DECISION DELEGATED TO DEVELOPMENT MANAGER
--

Application No:	H05-0990-19	Applicant:	Mr P Barnes
Proposal:	Removal of hedge and erect wall and railings to front of dwelling		
Location:	The Limes 21 Fleet Road Fleet		
Terminal Date:	28th November 2019

ELEVATION ON PROPOSED FRONT WALL

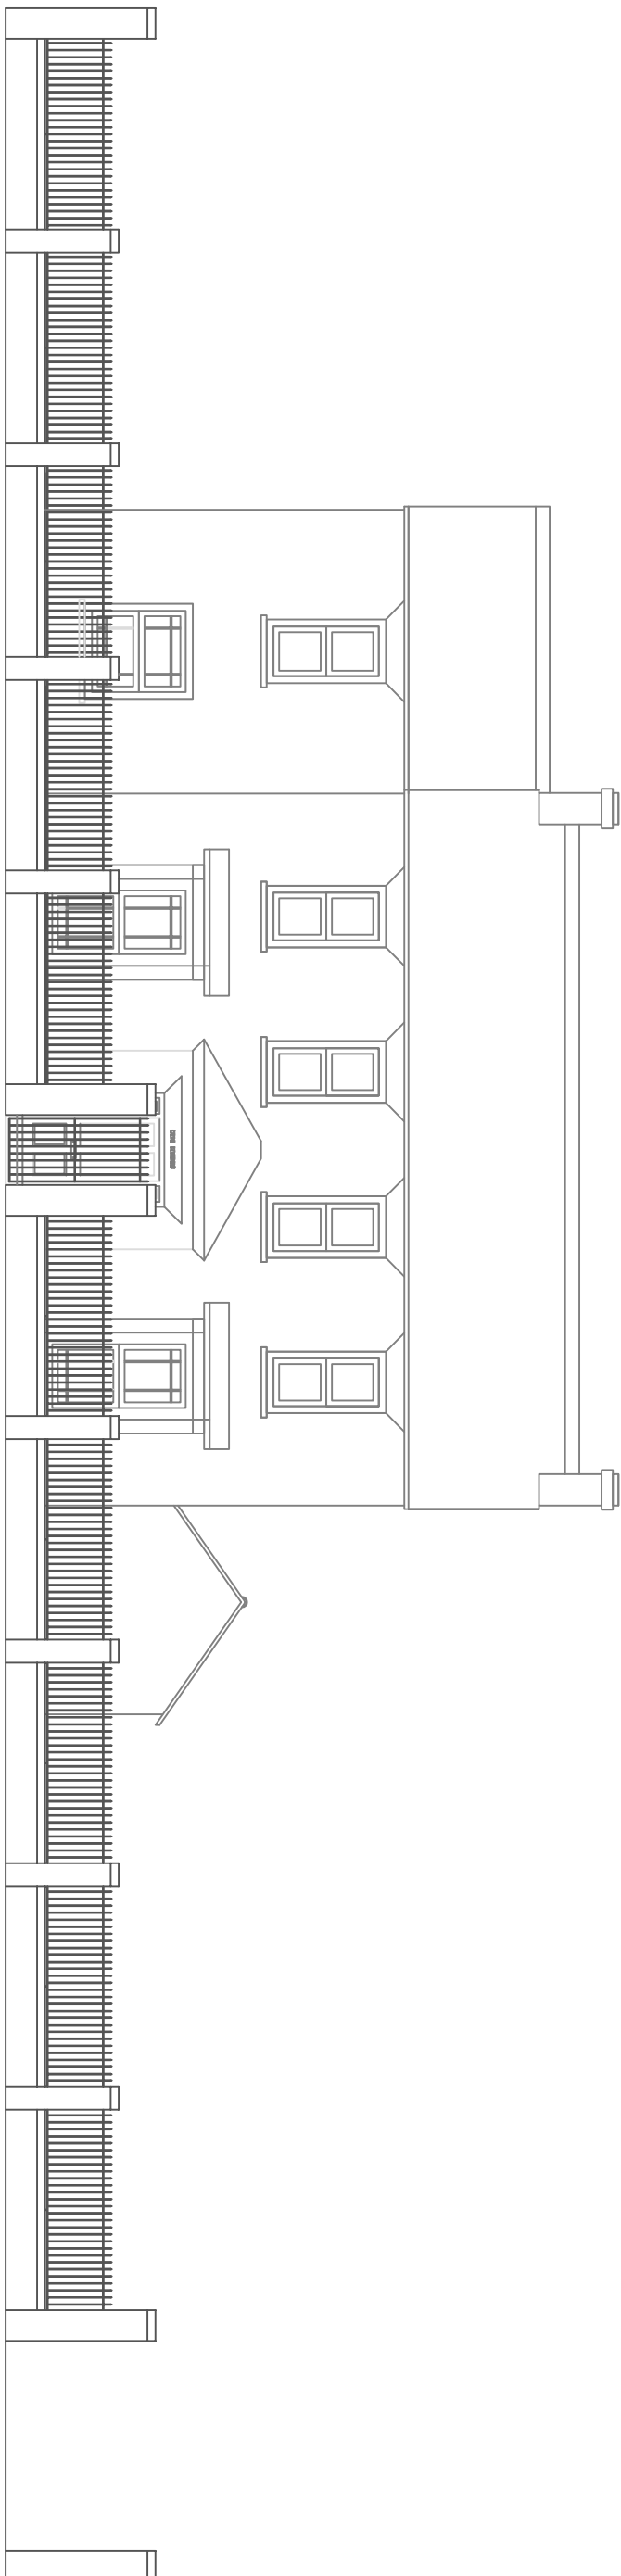
Wall will exceed 2 and a half metres which may be against rules and regulations

Resident's complained that the wall would exceed 2 and a half metres at its highest point and that this would be against planning regulations. Whilst it is true that the proposals will exceed 2.5m, there is no regulation which states that a fence exceeding 2.5m in height is not permissible. Part 2, Class A of the Town and Country Planning (General Permitted Development) (England) Order 2015 states that if a fence is proposed which is adjacent to the highway and would exceed 1m in height it requires planning permission. In view of this, the applicant has filed this application.

The proposed wall will exceed the 1m permitted development limit for walls erected adjacent to the highway. However, the Local Highways Authority have been consulted and have returned a comment of no objections. As such the Local Planning Authority must take that to mean there is no discernible risk to the Highway or road safety presented by this proposal.

The Local Planning Authority seeks no amendment to the design or layout of the proposed wall. This is because it is considered that the proposed design is sympathetic to the host property and the surrounding area.
